A1 Birtley to Coal House

Scheme Number: TR010031

Statement of Common Ground with Gateshead Council

Version	Date	Status of Version
Rev 1	20 April 2020	Draft

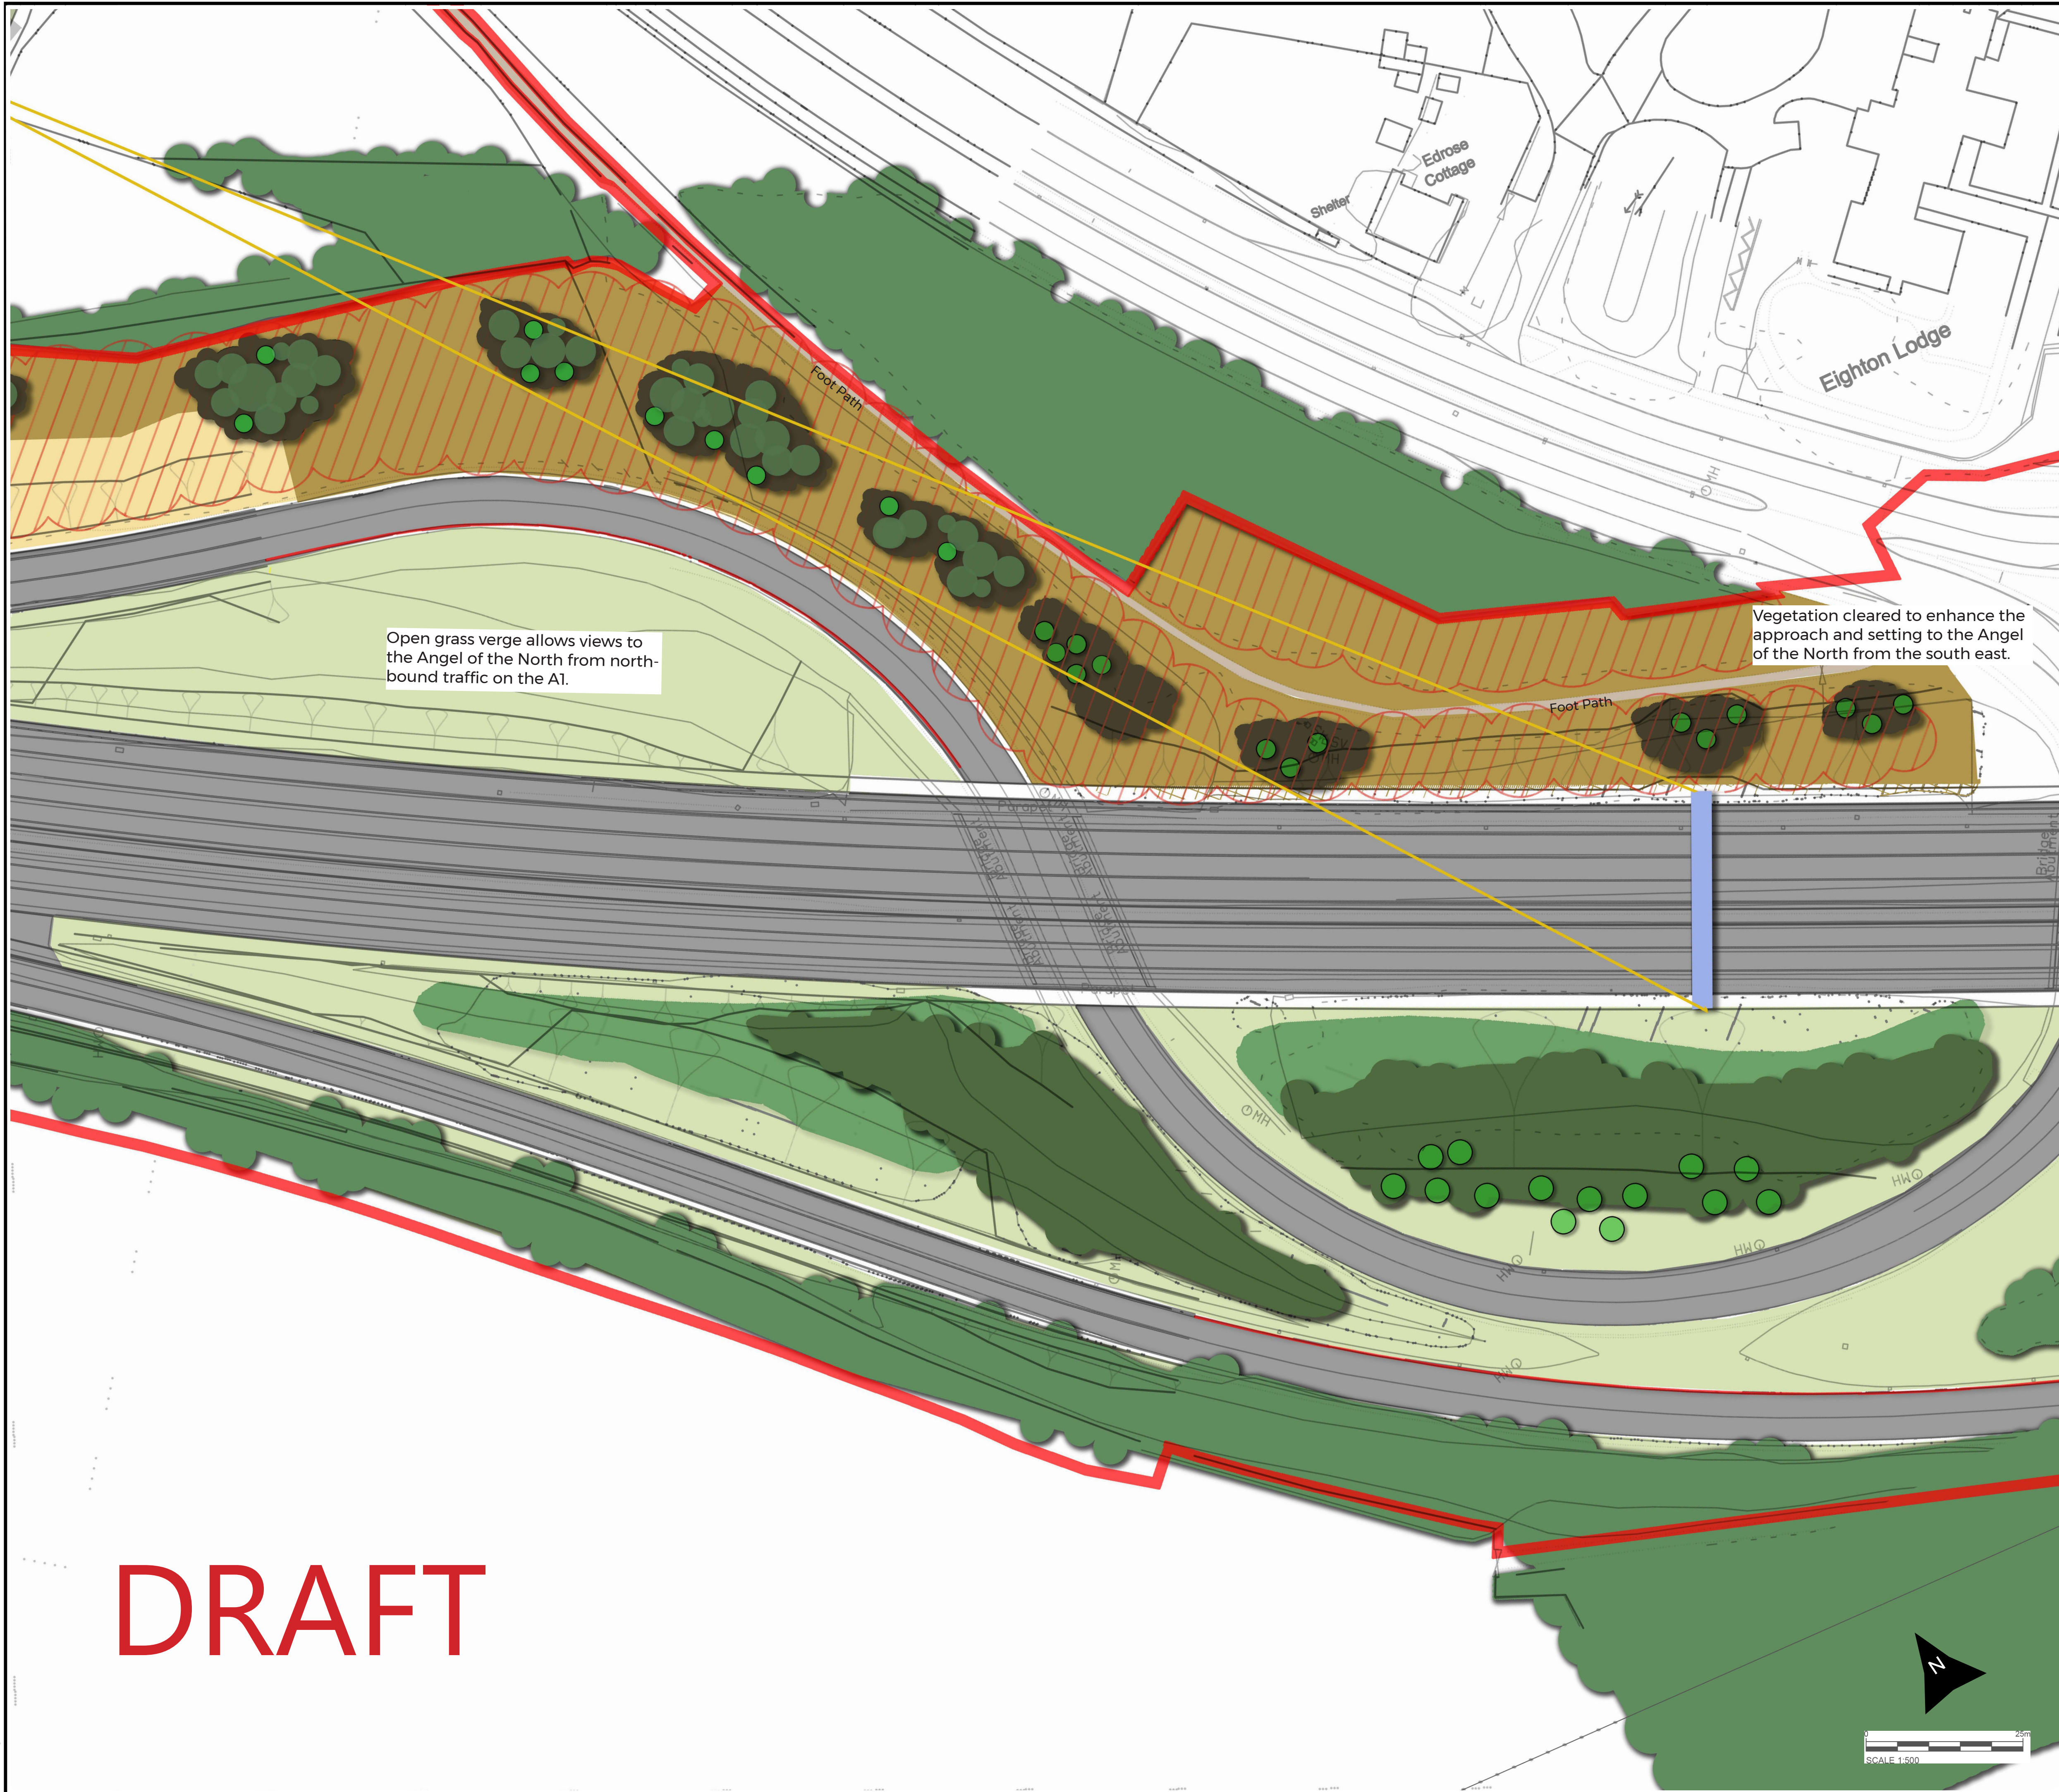
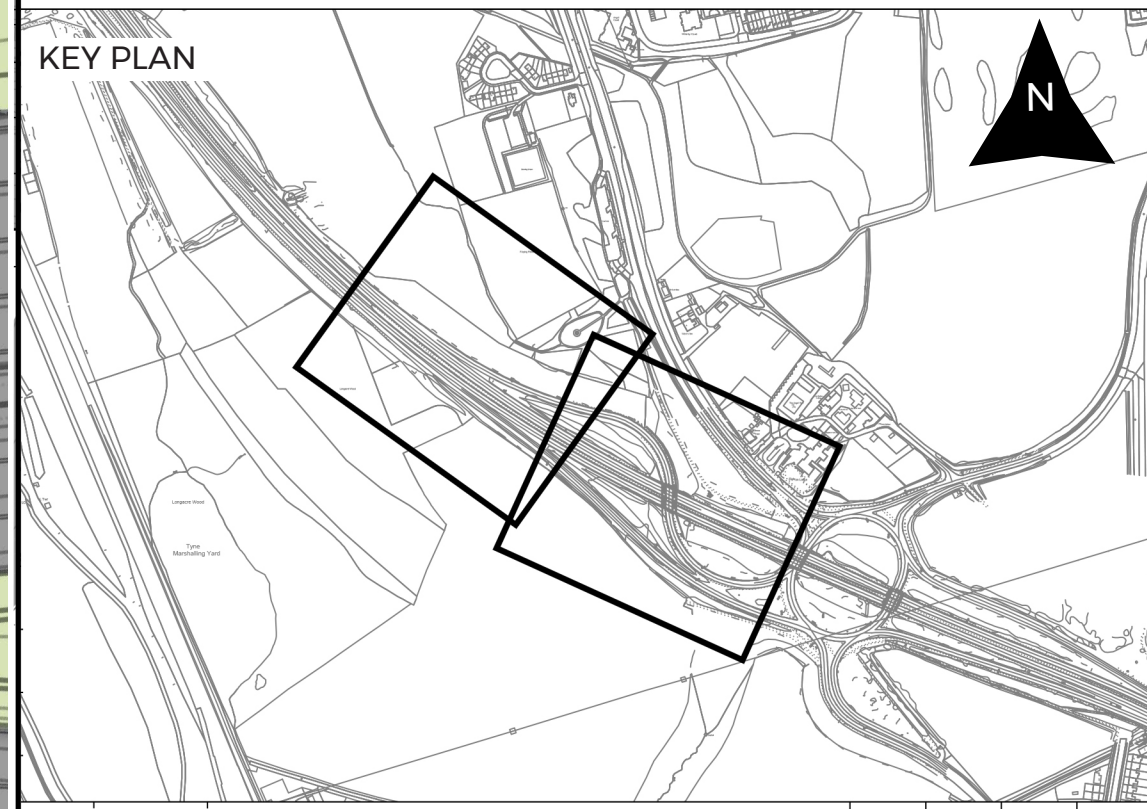
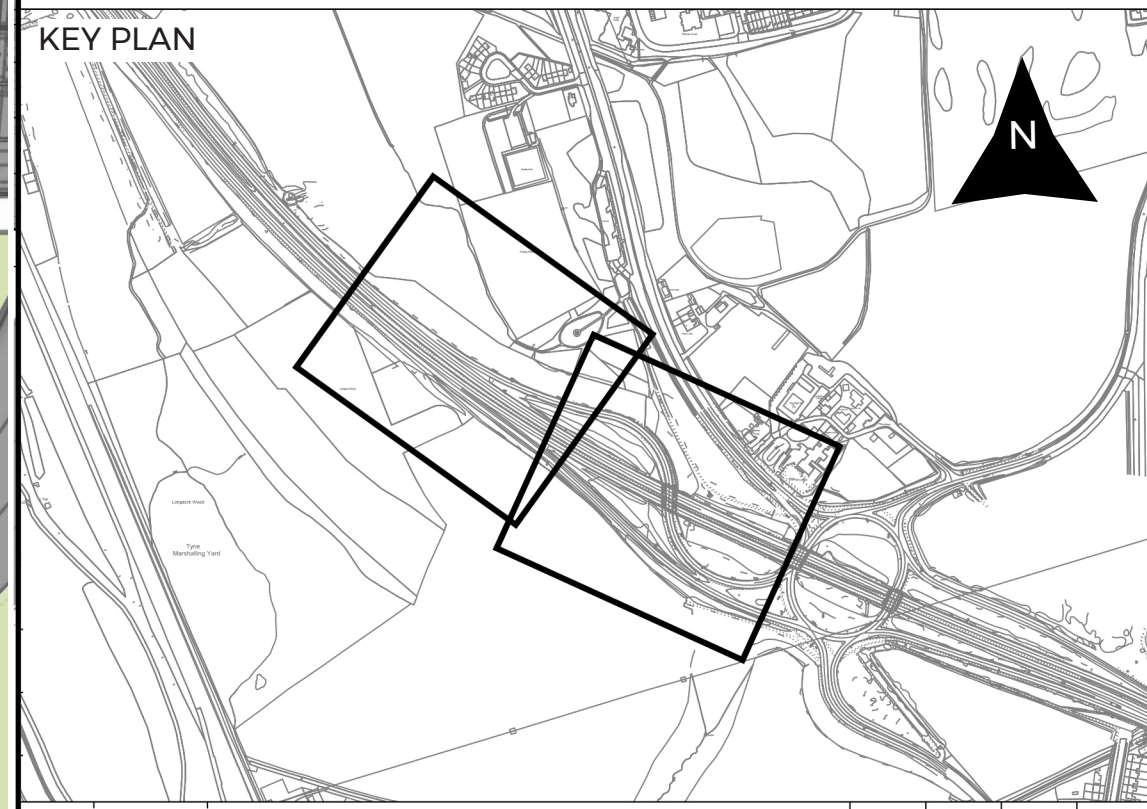
Section	Sub-section	Gateshead Council Position	Highways England Position	Status
Environmental Statement - Chapter 6: Cultural Heritage	6.8 Potential impacts	In a meeting on 08/03/2018 Gateshead Council's Conservation Officer asked Highways England to consider removal of trees along the A1 that currently obstruct the view of the Angel of the North.	Highways England agrees that the removal of existing trees has the potential to bring beneficial impacts on the Setting of the Angel of the North. However, removal of some of the trees within this location is restricted for ecological reasons.	Under Discussion
		<p>Gateshead Council recognises tensions between artist, climate change and ecology views. Gateshead Council requested visuals of the proposed A1 works showing the landscape in its finished (post construction) massing would assist in developing the detailed landscape design and enable views to be managed alongside gantries and other infrastructure.</p> <p>Agreed in November 2019 that a single joint landscaping scheme should be developed by Highways England and Gateshead Council. Discussions are ongoing.</p>	<p>Following a meeting on 9 April 2020 between Gateshead Council Landscape and Ecology Officers and Highways England environmental specialists there is an agreement in principle to the design of the landscape and habitat mitigation proposals within the Order Limits and associated with the interface of the Scheme and the Angel of the North. An updated version of The Landscape Mitigation Design, Figure 7.6 of the ES [APP-061] showing landscape and habitat mitigation planting around the Angel of the North will be produced. It is understood that agreement to this plan will be subject to further discussions internally within Gateshead Council</p>	Under discussion

Section	Sub-section	Gateshead Council Position	Highways England Position	Status
		<p>are ongoing regarding the details of the landscaping scheme.</p> <p>Gateshead Council adopted a preferred landscape scheme on 19 February 2020 and provided Highways England with details of it.</p> <p>At the meeting on 9 April 2020 Gateshead Council requested further clarification on the works due to be completed within the Order Limits which fall within Longacre Wood Local Wildlife Site (LWS). The ecological representative was concerned regarding the habitat loss, as Gateshead Council consider this section of the LWS to be of ecological value.</p>	<p>the removal of vegetation as part of the Scheme.</p> <p>Once the Scheme is operational, there would be some visual changes to the character of the surrounding areas, however, these changes would only be significant for Landscape Character Area 1, Public Right of Way (PROW) P3 and Longacre Wood.</p> <p>In response to these requests for clarification from Gateshead Council's Highways England took an action to include control measures for works within the LWS to reduce impacts on Longacre Wood. These design changes are currently ongoing.</p>

Section	Sub-section	Gateshead Council Position	Highways England Position	Status
Chapter 7: Landscape and Visual	7.8 Potential impacts	<p>Gateshead Council are seeking additional details on landscape design to mitigate for the overhead signage gantries.</p> <p>Further discussions took place at a Skype meeting on 9 April 2020 regarding impacts on views of Angel of North from the A1 during operation of the Scheme. Gateshead Council requested further discussions on minimising gantry impacts and these discussions are ongoing.</p> <p>The Council states that that there is a material and negative impact on the Angel of the North resulting from the scale of the new Allerdene footbridge and the number and position of the proposed gantries. The Council believes that this impact can be offset by the implementation of the 'Revealing the Angel' scheme in the 'Options Appraisal for Managing and Enhancing the Angel' report, on both Council and Highways England</p>	<p>Section 7.8 of Chapter 7: Landscape and Visual of the ES [APP-028] summarises the predicted construction and operation impacts of the Scheme.</p> <p>During construction, the Scheme the removal of roadside vegetation would, in places, expose views of the existing A1, associated construction activity and traffic management. The Landscape Mitigation Design, Figure 7.6 of the ES [APP-061] which identifies where existing vegetation would be removed and where new planting would be created is in the process of being updated to take into account feedback received from Gateshead Council and discussions continue to be ongoing. The impact of vegetation removal would be minimised due to either the current shape of the land, retained vegetation within the adjacent landscape or existing buildings.</p>	Under discussion
